Appendix L - The Sandstone Precinct– SSD 6751 MOD 2 and SSD 7484

Response to Government Agency Submissions

Shadows

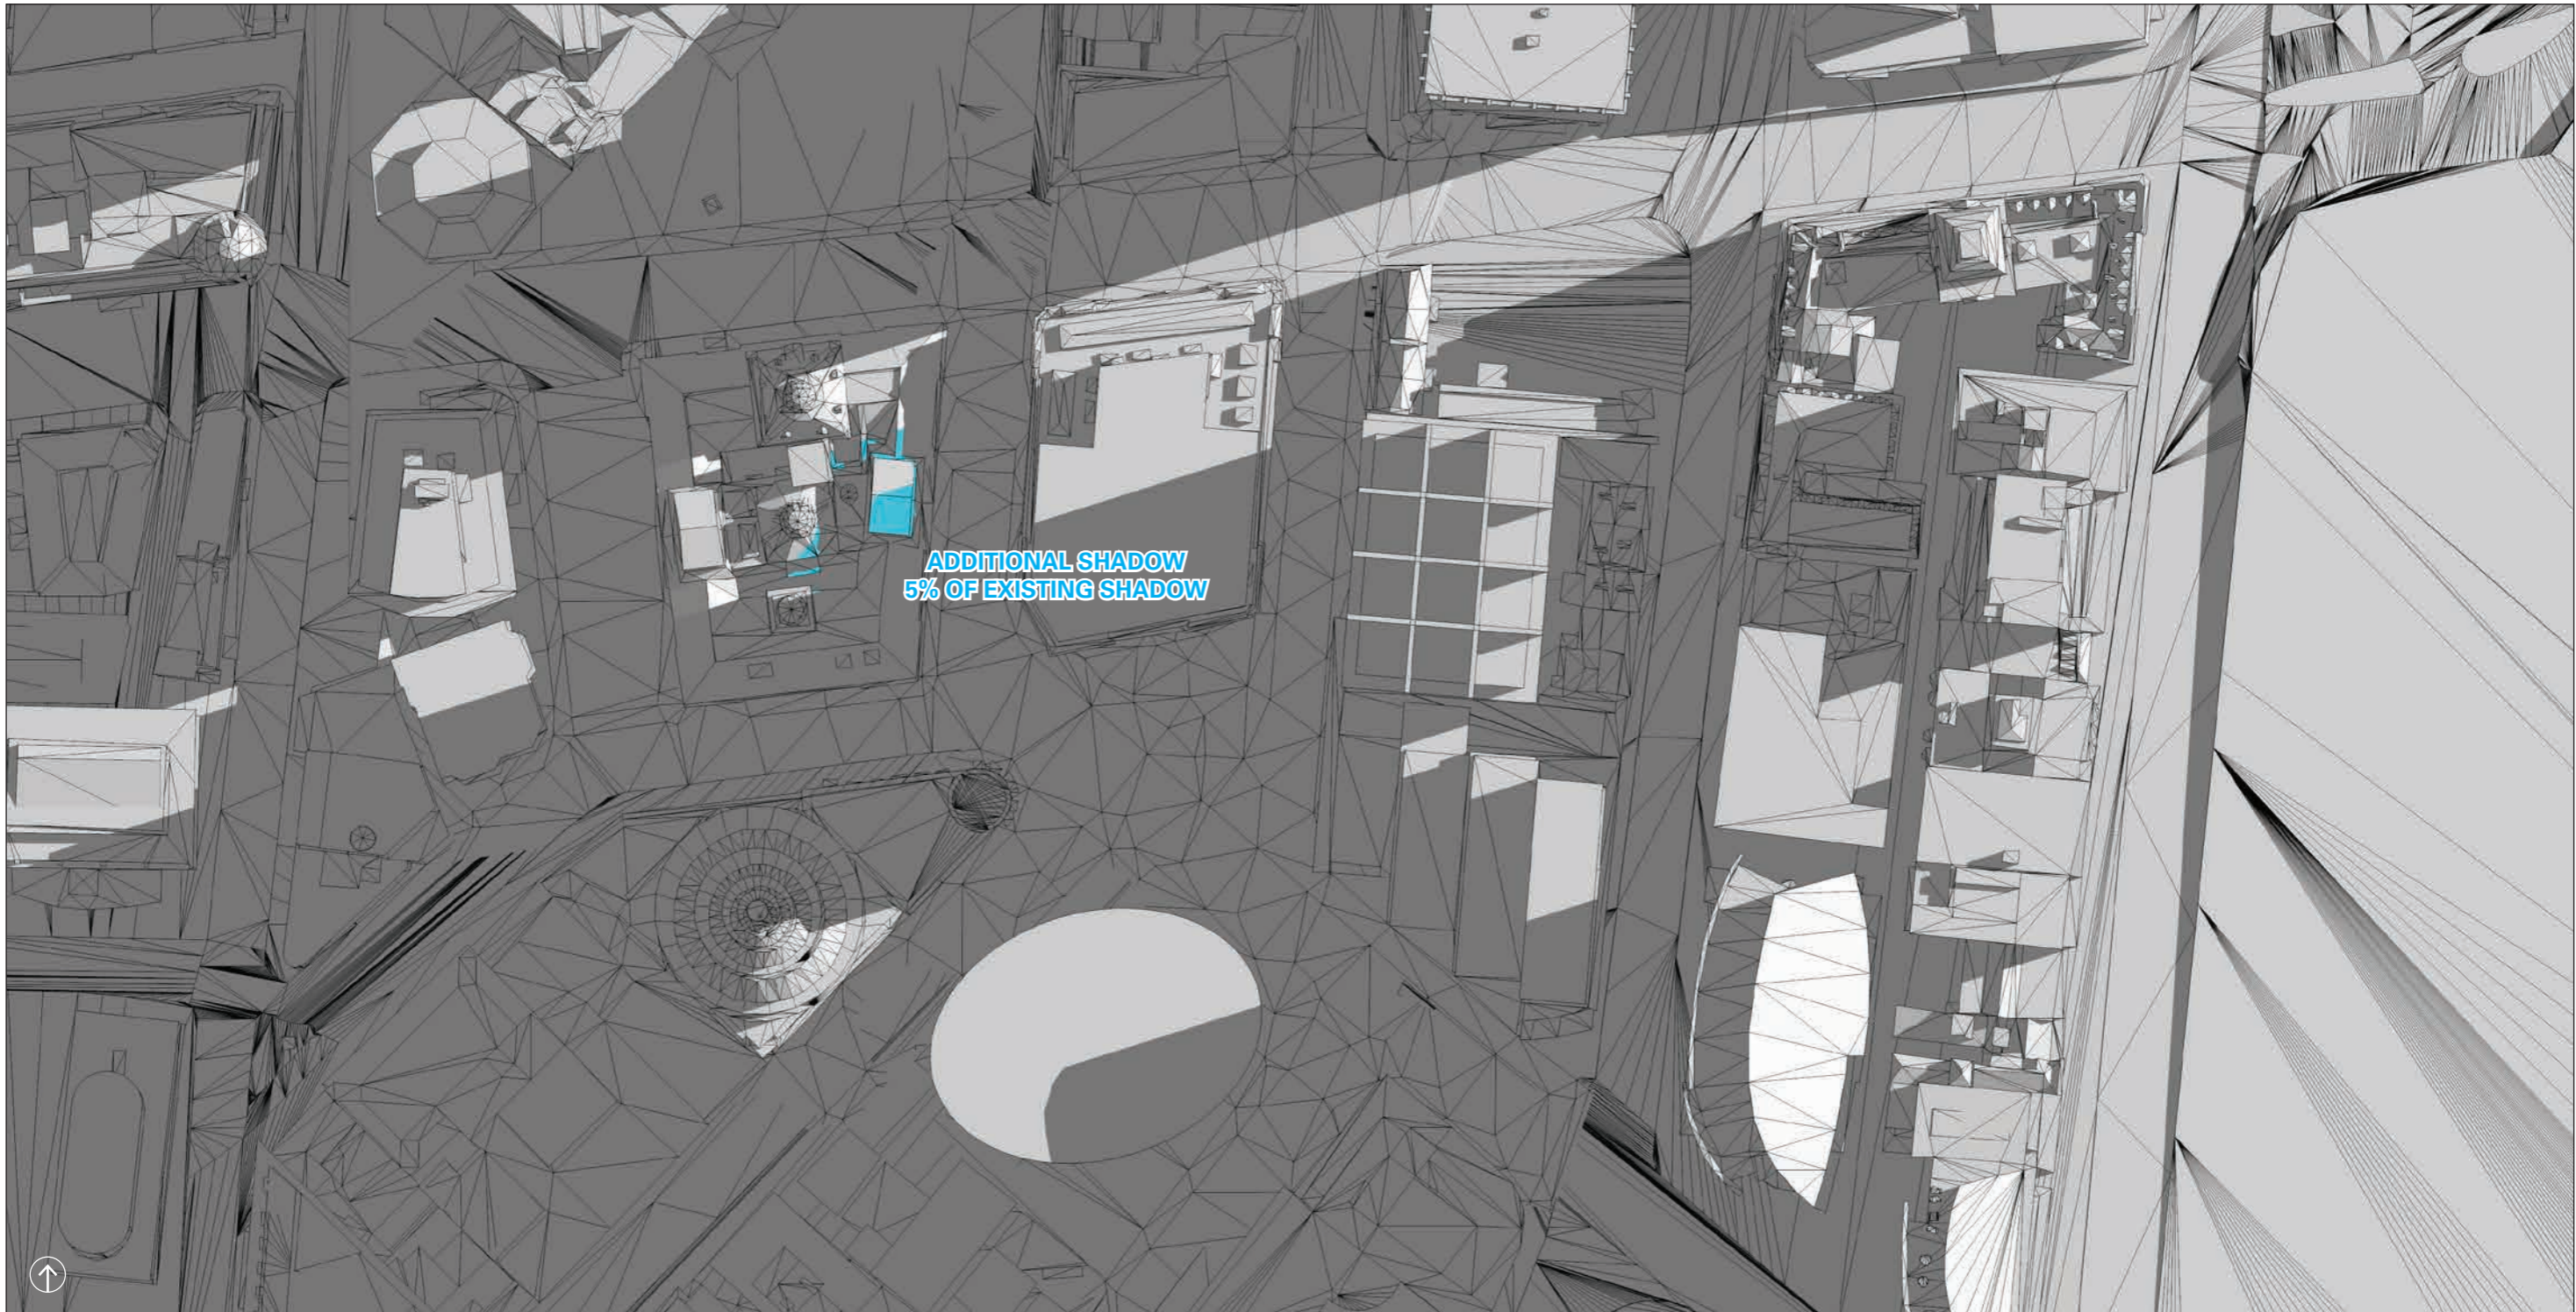
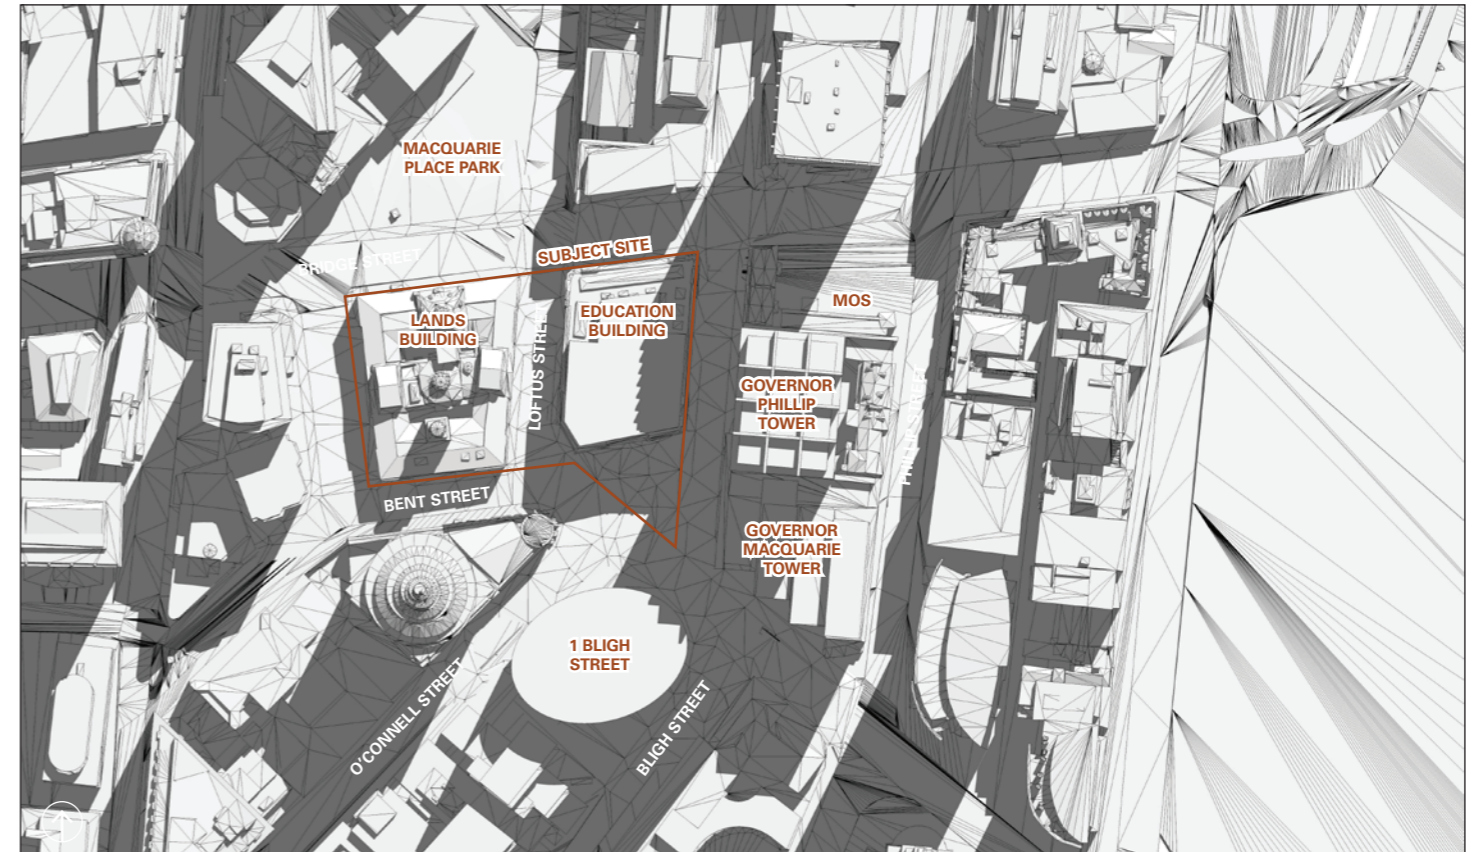
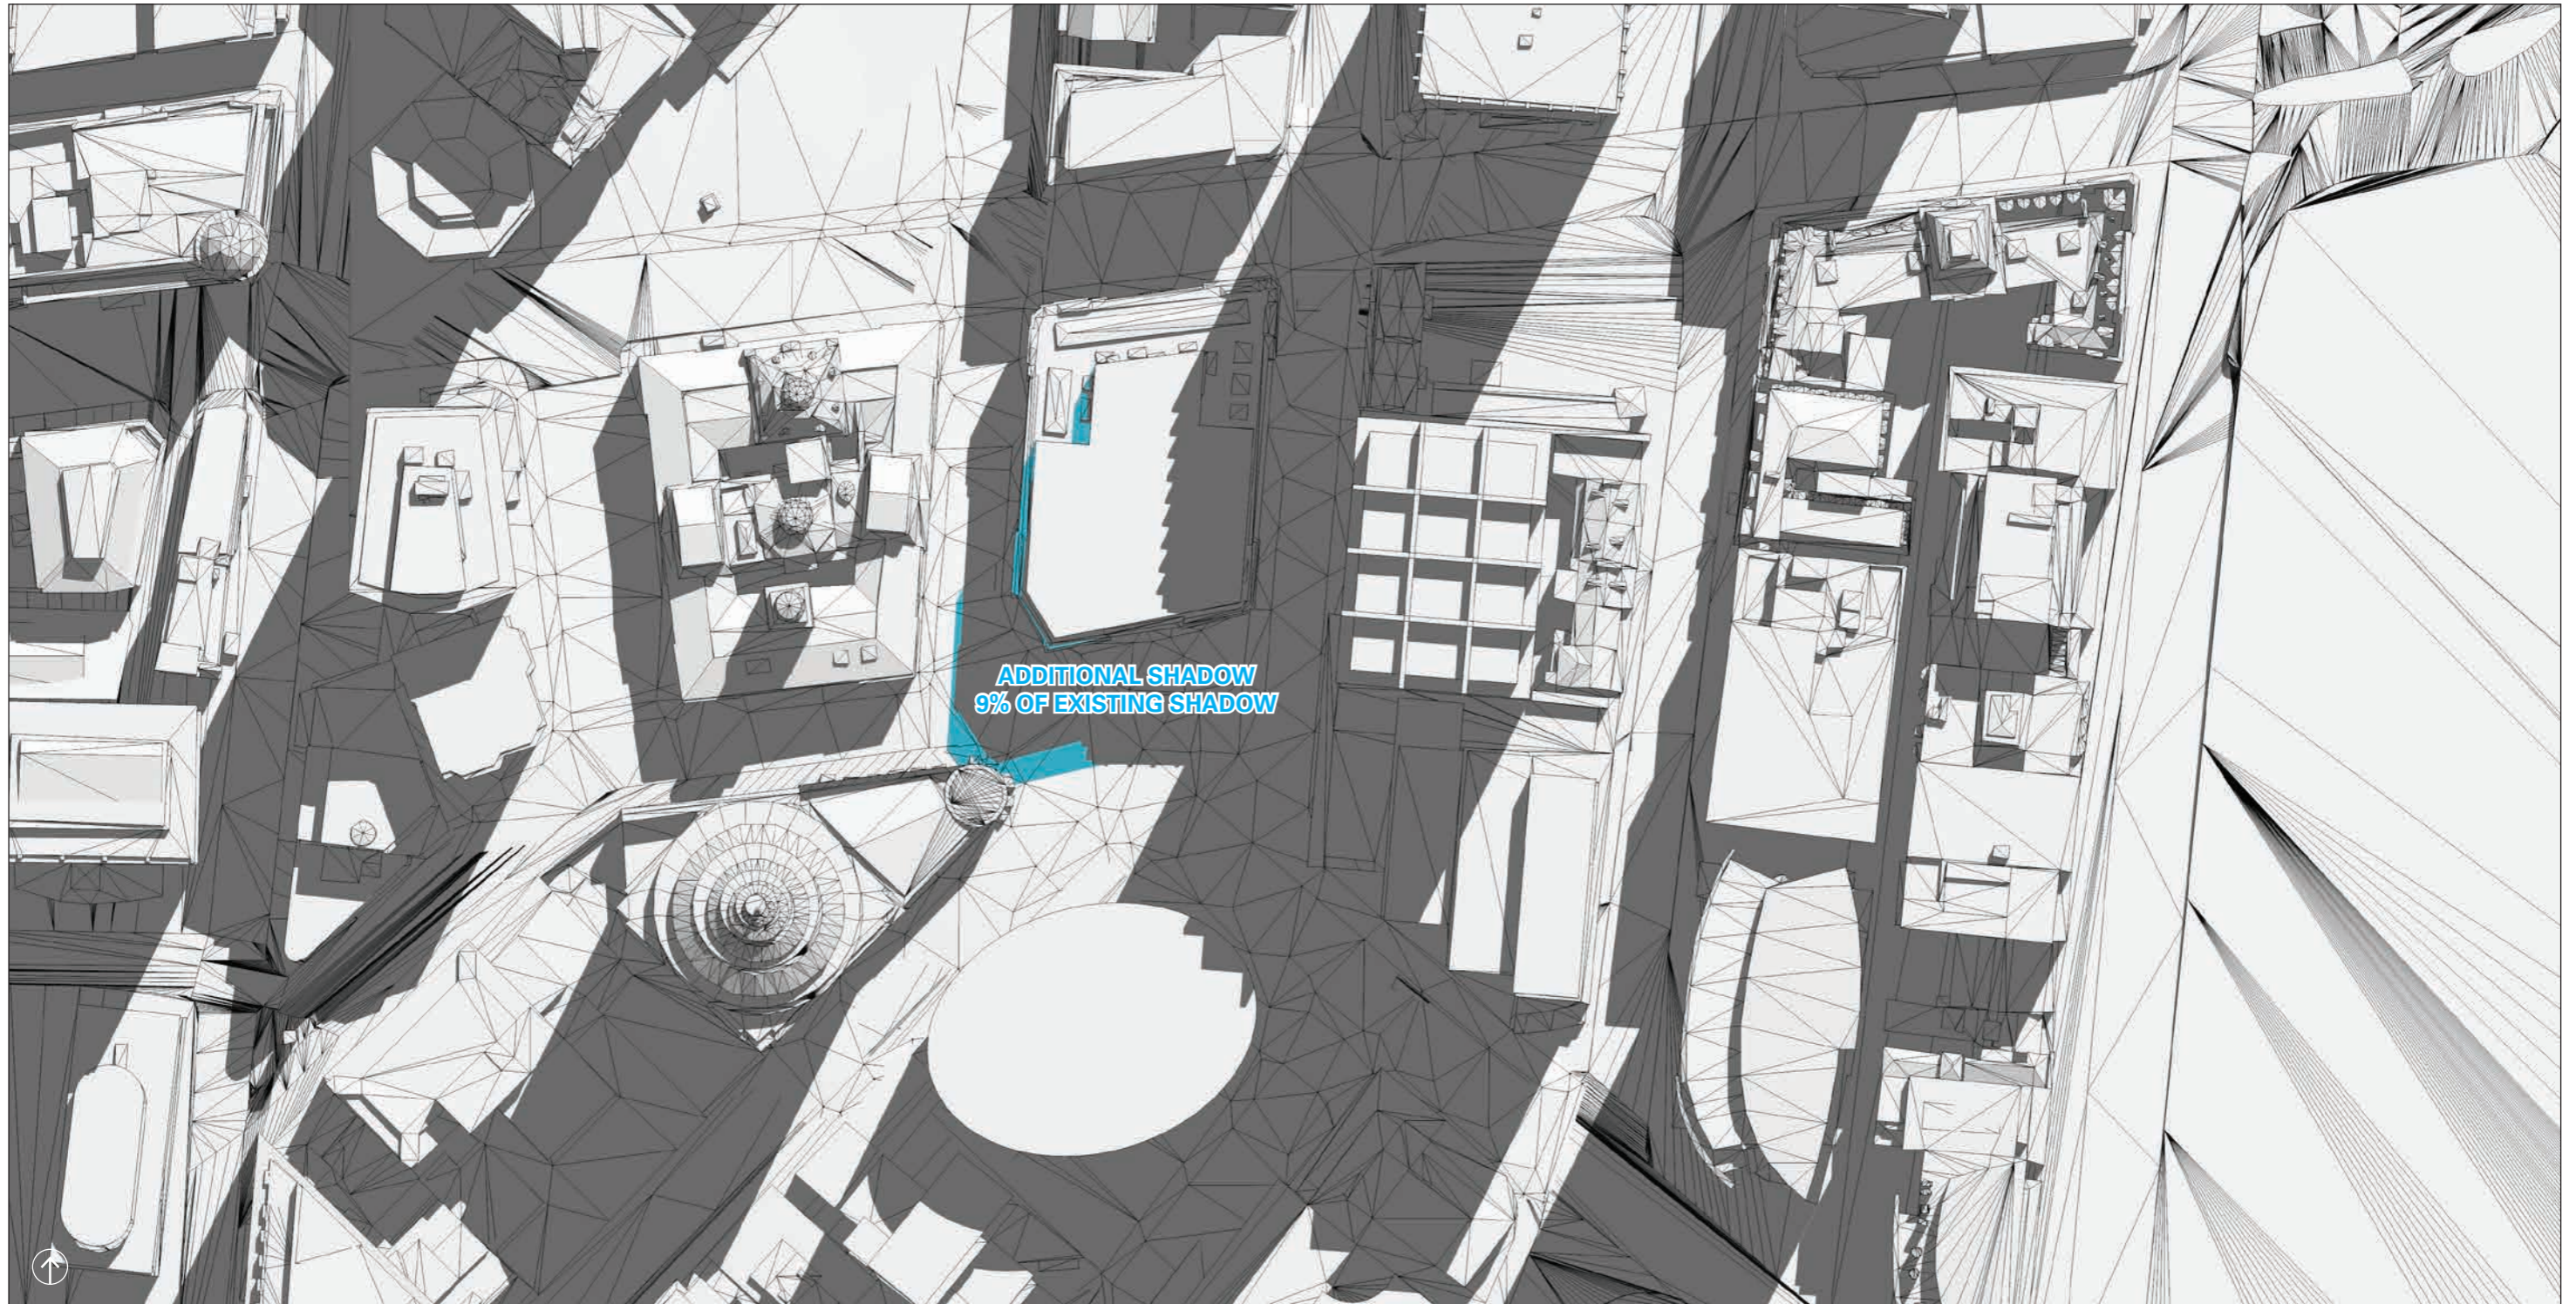
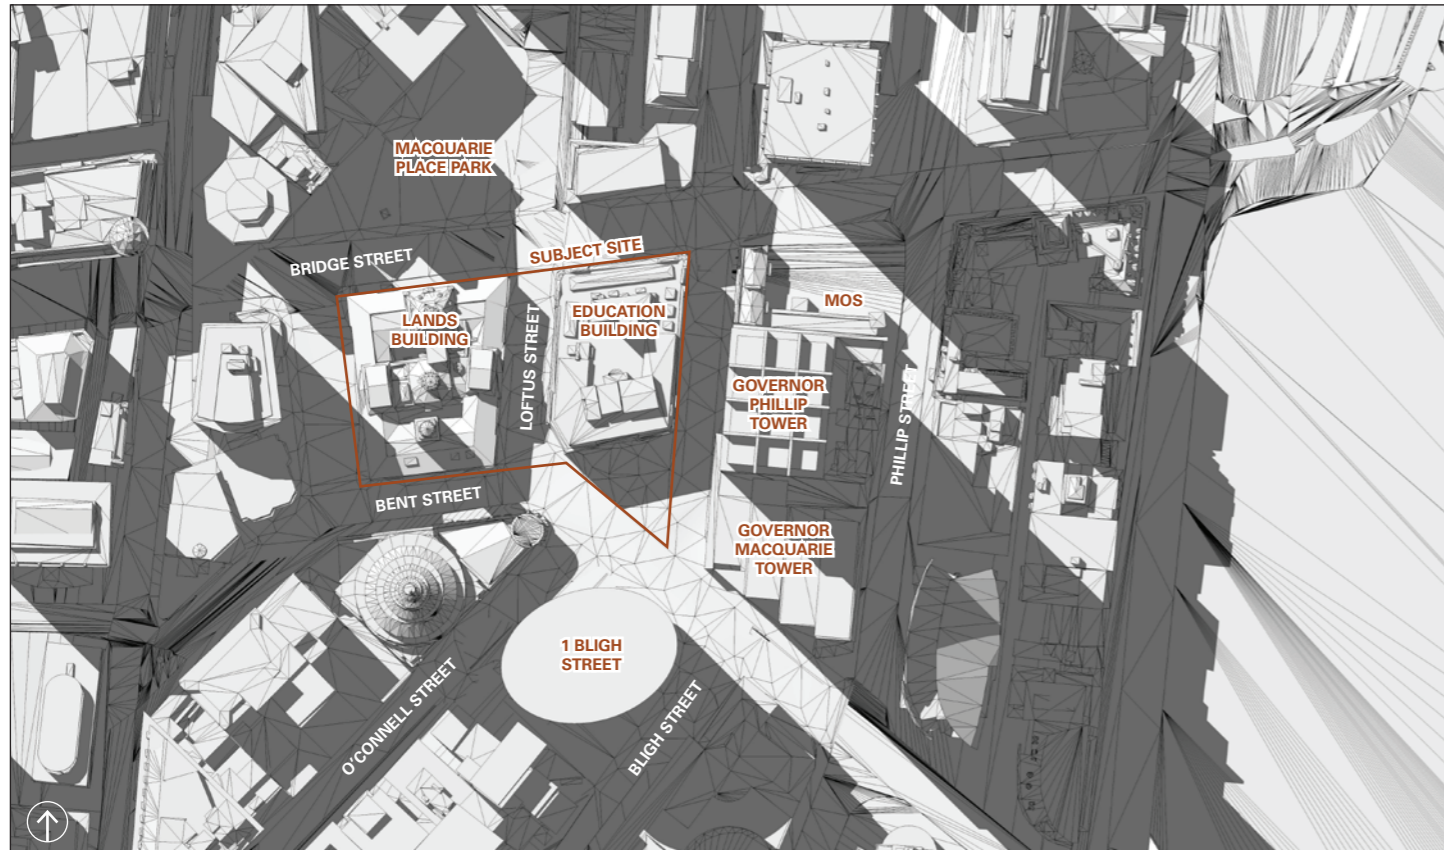
<ul style="list-style-type: none"> Any increase to the roof level of the Education Building would impact upon solar access of Farrer Place and is not supported. 	Additional shadow diagrams have been prepared that demonstrate the shadowing of Farrer Place under Stage 2 is less than that of the approved Stage 1 envelope (Refer to Appendix J).
<ul style="list-style-type: none"> Both the Lands and Education buildings are of State Heritage significance and should be treated accordingly. Lessening the impact on one building only to justify increasing heritage impact on another is not an acceptable heritage outcome. 	Noted. The use of the proposed buildings and roof envelope of the Education Building was approved at Stage 1.
<ul style="list-style-type: none"> The Trust voices its concerns about the potential decrease in public space in Farrer Place through the construction of a new vehicular drop-off leading from Bent Street. 	The reduction of public space by the new drop off will be offset by the increased public space created at the intersection of Loftus Street and Bent Street. The nett result is that Farrer Place will remain the same size.
